YORKSHIRE GARDENS TRUST

31st December 2024

2024/93411/E LBC Internal and External Alterations and Landscaping Alterations Works, Public Conveniences, Dewsbury Mansion House, Crow Nest Park, Heckmondwike Road, Dewsbury Moor, Dewsbury WF13 2SG

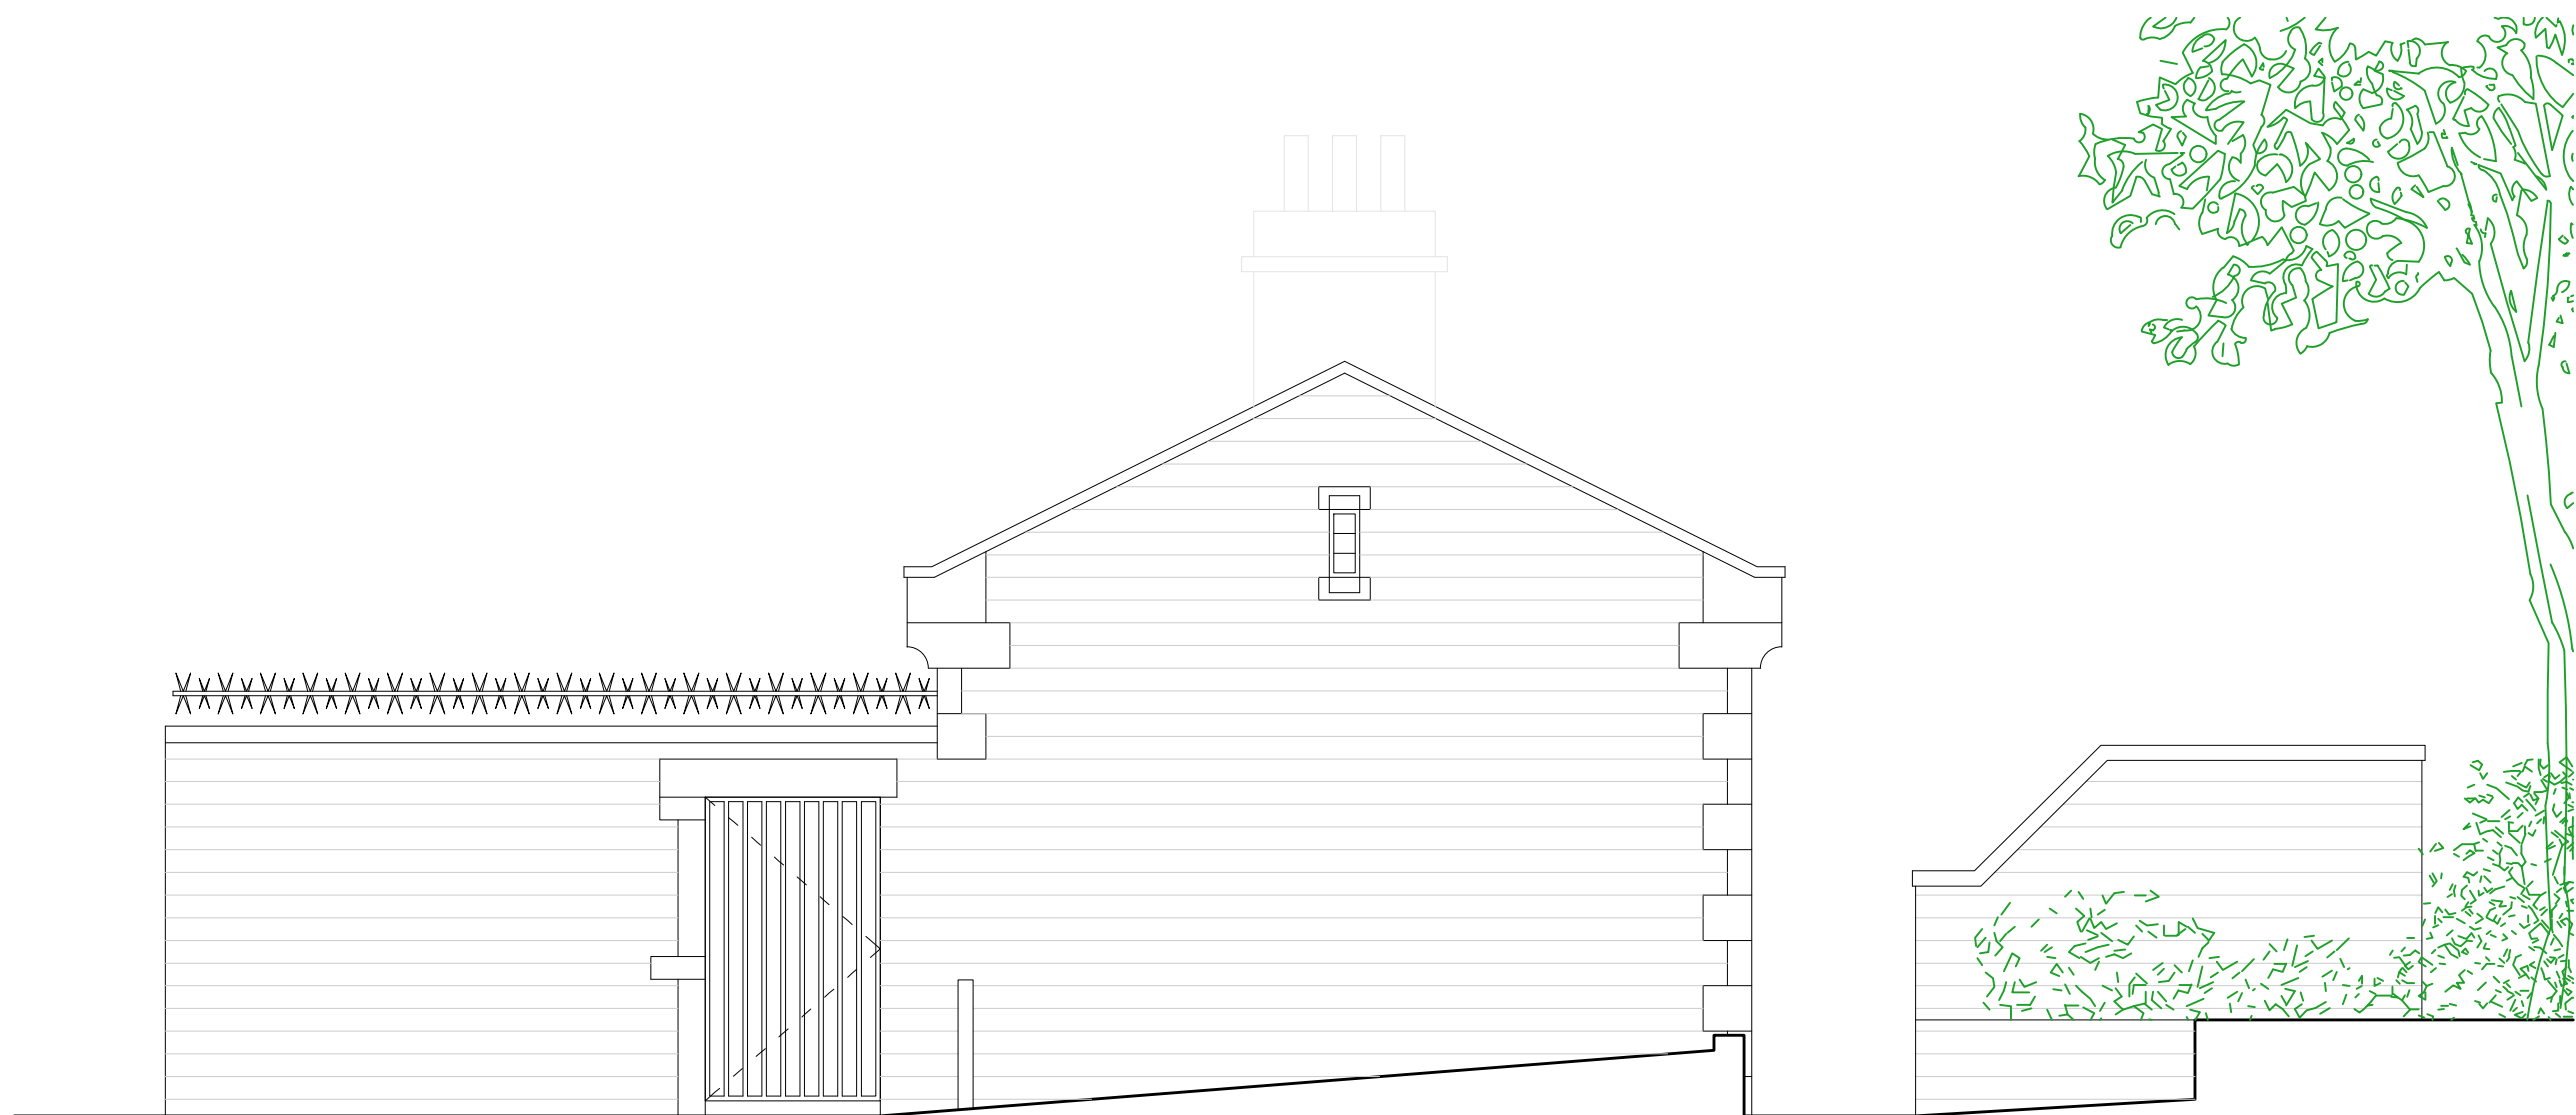
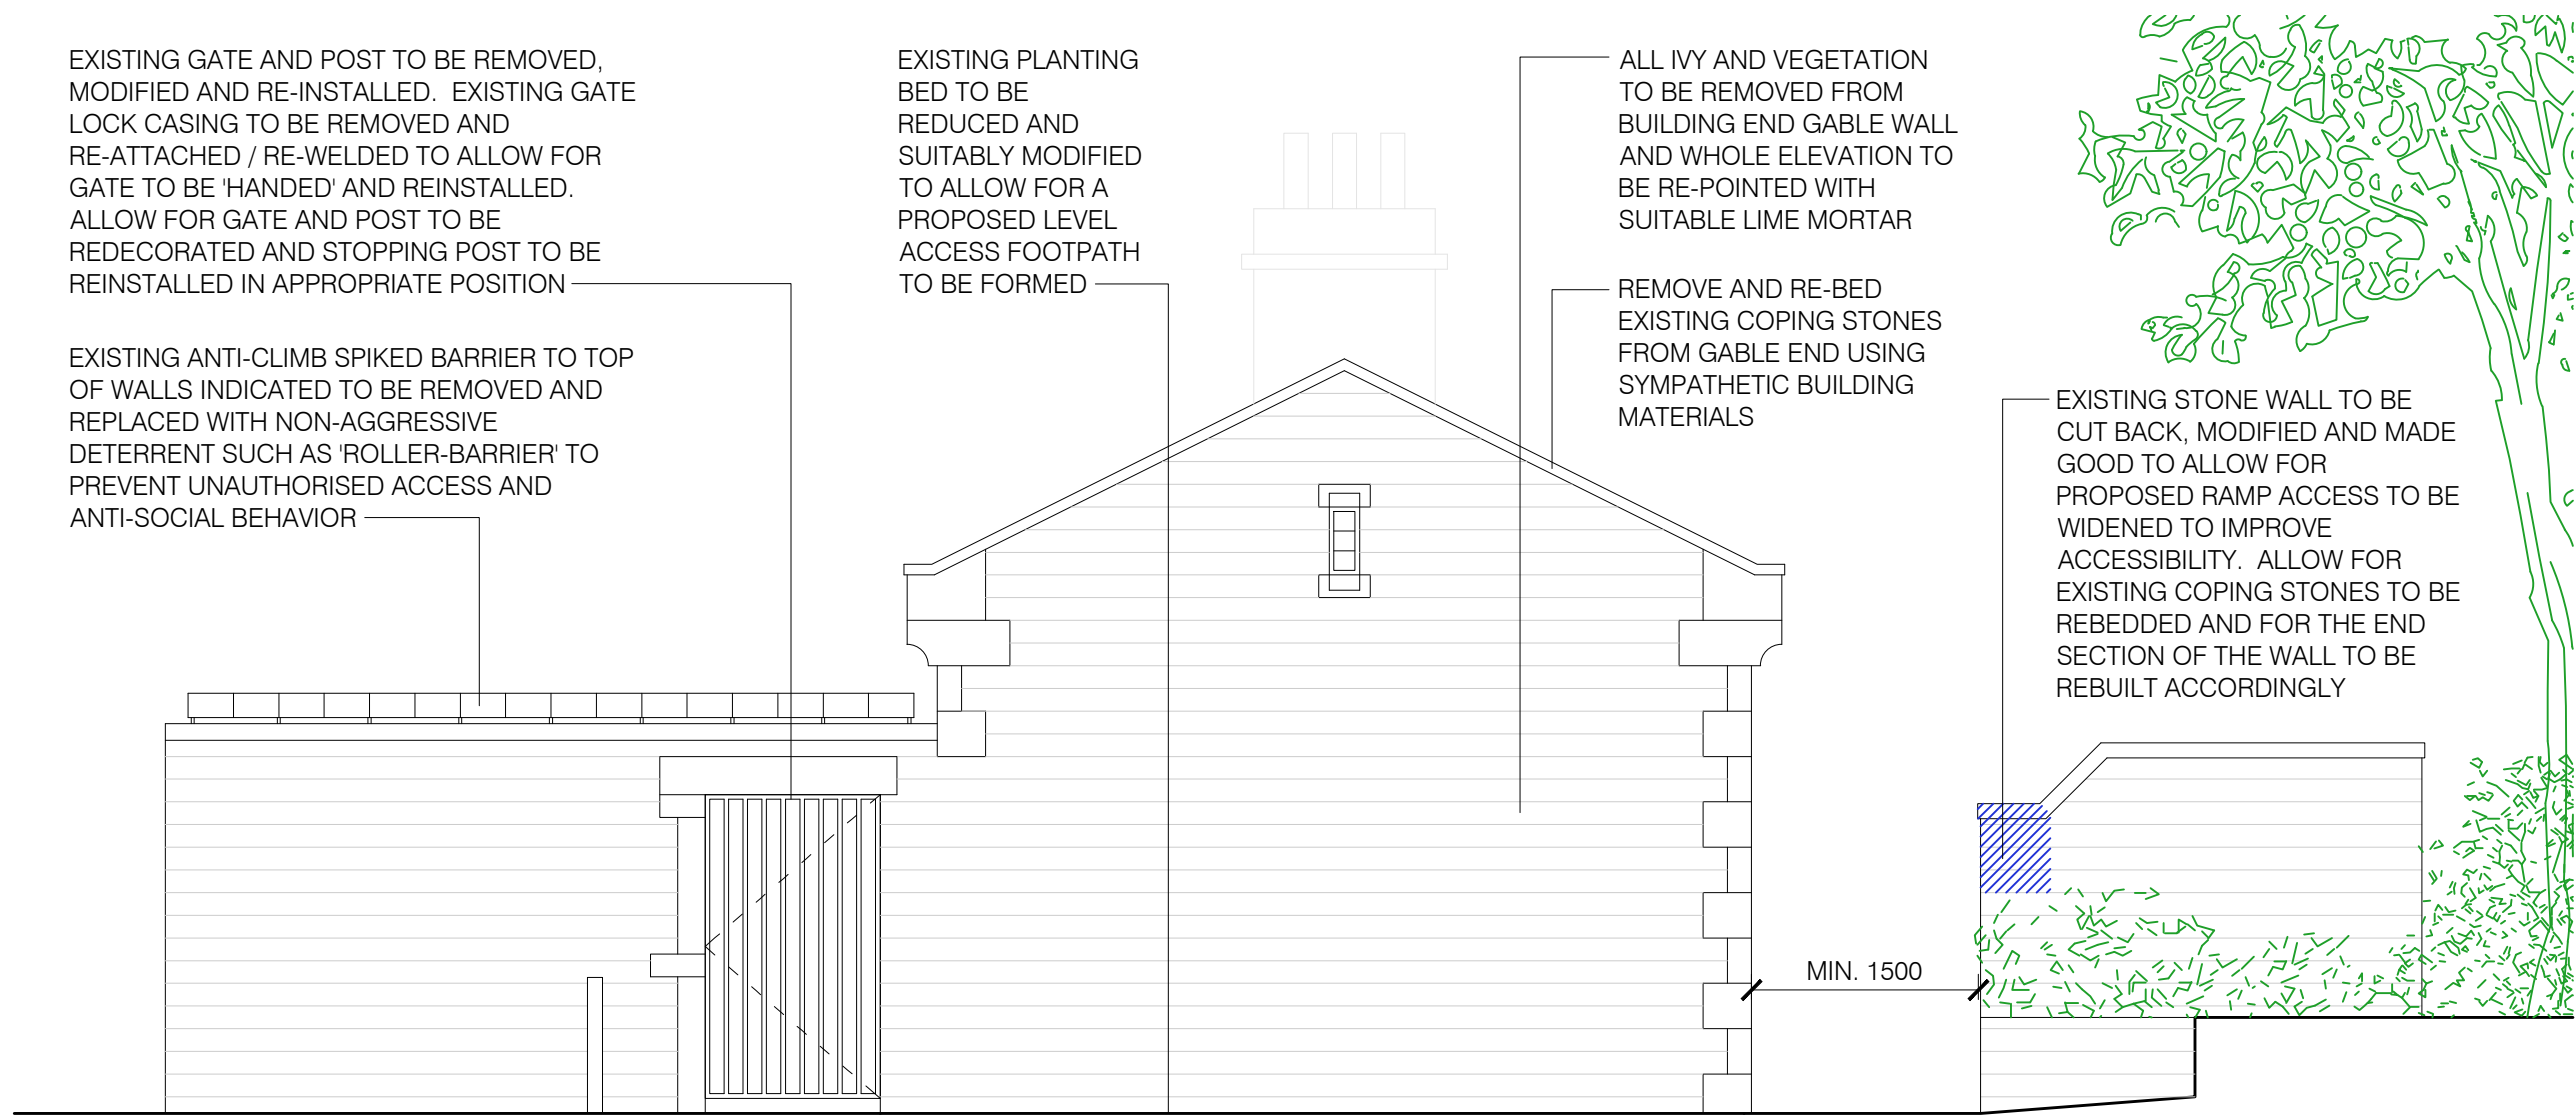
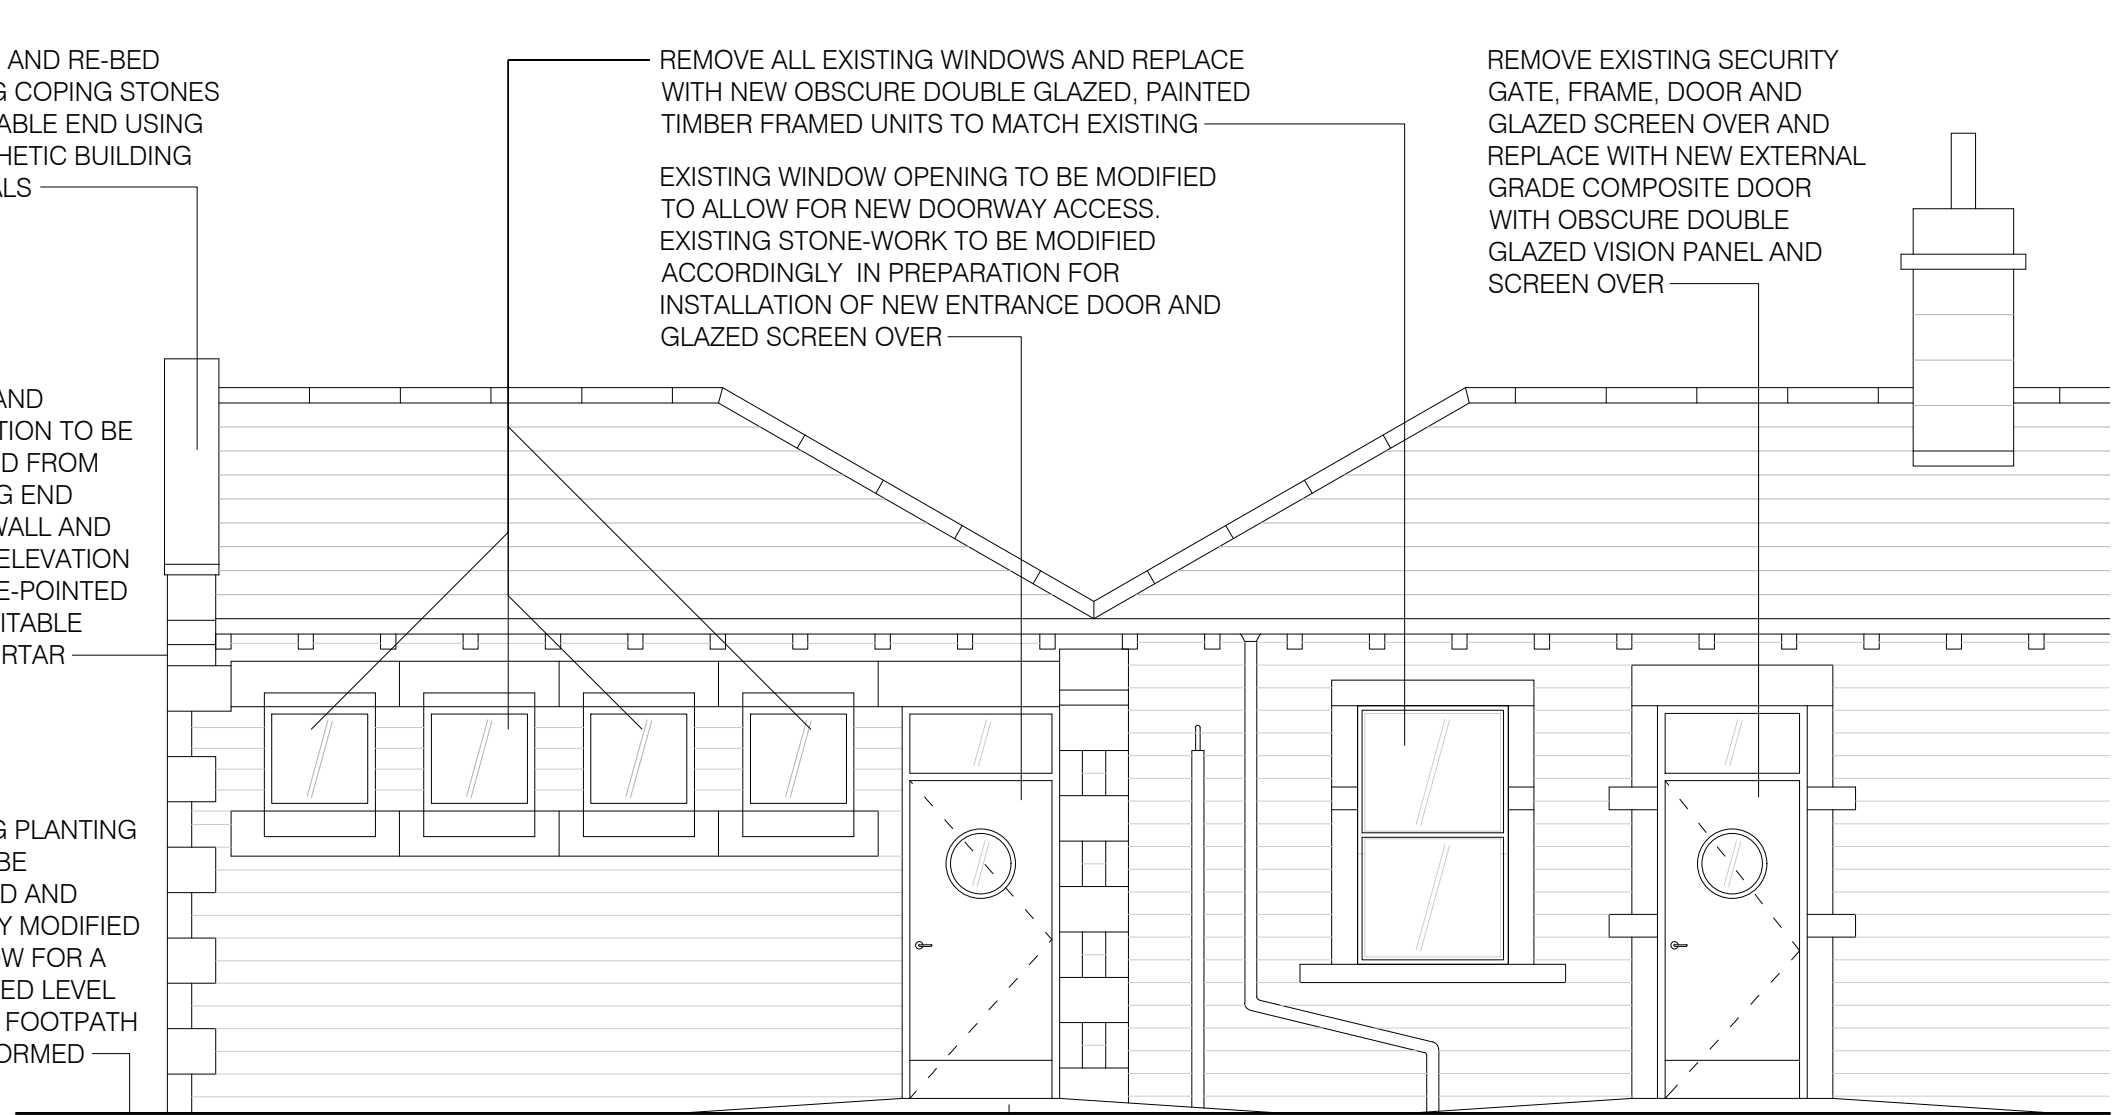
There seems to be 3 areas of hard surfacing to be changed or retained as shown on the Proposed Landscaping Details: a) 'Approx 75sqm existing external stone flooring slabs to be removed and replaced with suitable tarmacadam type floor finish...' This is the long length along the building.

We are disappointed by the proposal to replace 75sqm of existing external stone flooring slabs with a tarmacadam finish, especially in view of the very commendable Design, Access and Heritage Statement at 3: Site Information – see above.

In terms of the heritage and conservation of Crow Nest Park, the existing site photos of the building to be renovated in the Design, Access and Heritage Statement show how well the stone flooring slabs 'fit' with the buildings. In our view tarmacadam will be an unsympathetic material in this context.

We understand that the surface needs to be easily negotiated by wheelchairs and children's pushchairs, but we consider that a competent paver can lay York stone paving slabs to a good standard, setting the slabs on a thin concrete substrate to prevent theft. Slabs are also a greener solution rather than petroleum-derived tarmacadam.

We strongly advise York stone paving slabs would be most appropriate for this area of Crow Nest Park despite many paths in the park now being tarmacadam. However, if the consensus is for tarmacadam, then we suggest that there is a coloured chip through it, to soften the impact slightly, especially as the soft landscaping is to be reduced.
